Town & Country Planning Act 1990 (as amended)
Town and Country Planning (Development Management Procedure) (England) Order 2015
Approval of details reserved by condition imposed under BR/281/18/PL relating to conditions 3-
Arboricultural meeting, 6-Construction Management Plan, 7-landscape scheme, 8-colour scheme of
materials and/or finishes, 9-new screen walls and/or fences, 10-covered and secure cycle parking
spaces, 12-dustbin enclosures, 13-electric vehicle charging & 14-decentralised, renewable and low
carbon energy supply systems.
99 Victoria Drive Bognor Regis PO21 2DZ

Condition Number 9

Decision:

PROPOSED SOUTH WEST ELEVATION

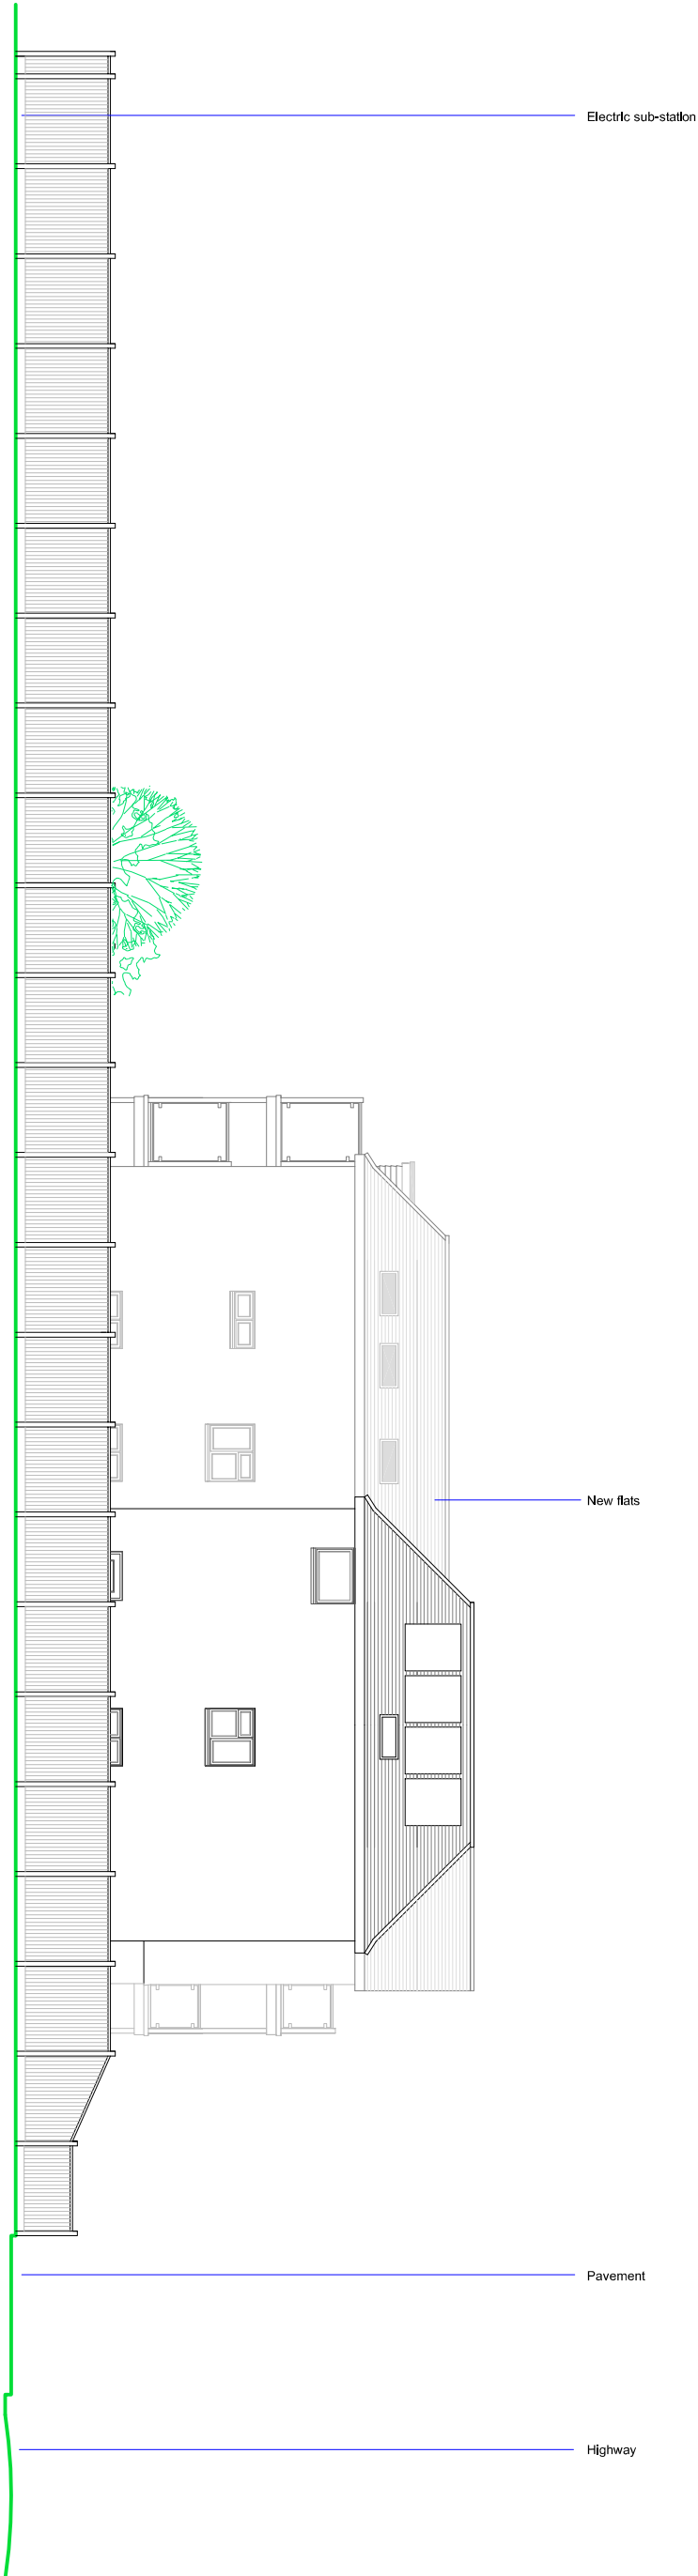
Arun District Council have decided to **REFUSE details reserved by condition for the following reasons:**
The submitted details in respect of the fencing and screen walls including the acoustic fence have been provided and assessed by the ADC EH Officer. No noise assessment has been submitted to identify the background or environmental noise level, specific noise level at facade of nearest receptor, impact to receptor or the performance required from an acoustic fence.

Please refer to the consultation response dated 26 January 2022. As such, the condition 9 cannot be discharged and you will need to make a revised submission.
